Online Comment

Application H02-1171-25
Location Rear of 12 Peterborough Road Crowland PE6 0BA
Proposal Proposed Bungalow & Garage

Name Parish Clerk
Address Crowland Parish Council

### BLOCK PLAN OF PROPOSED DEVELOPMENT

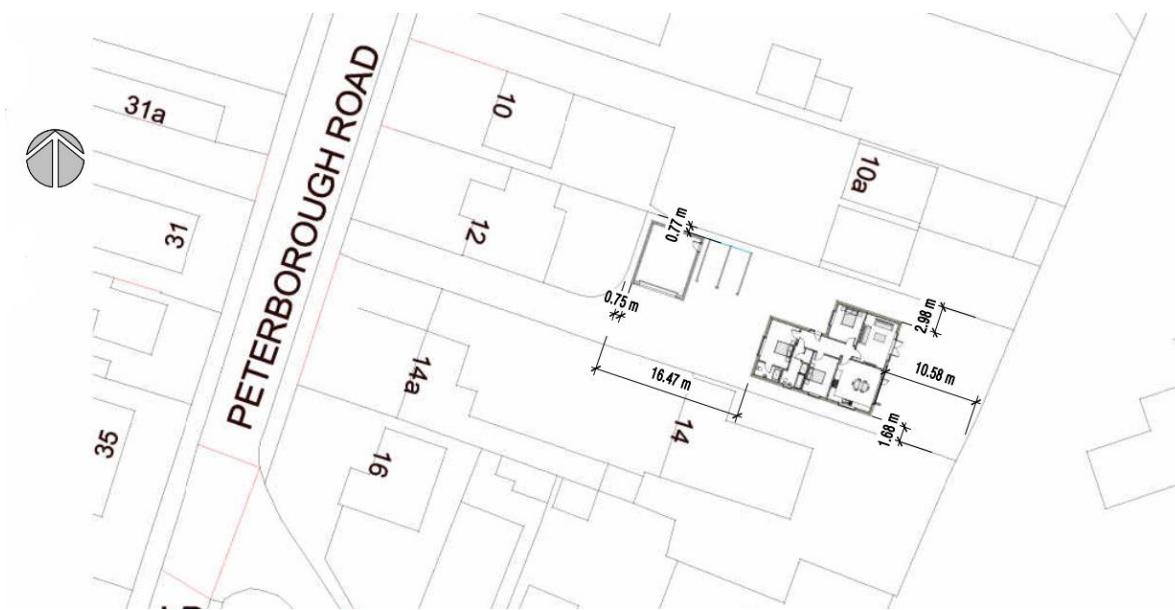
A question from the Committee was raised regarding parking arrangements for both buildings, with particular concern for Number 12 and where residents will be able to park.
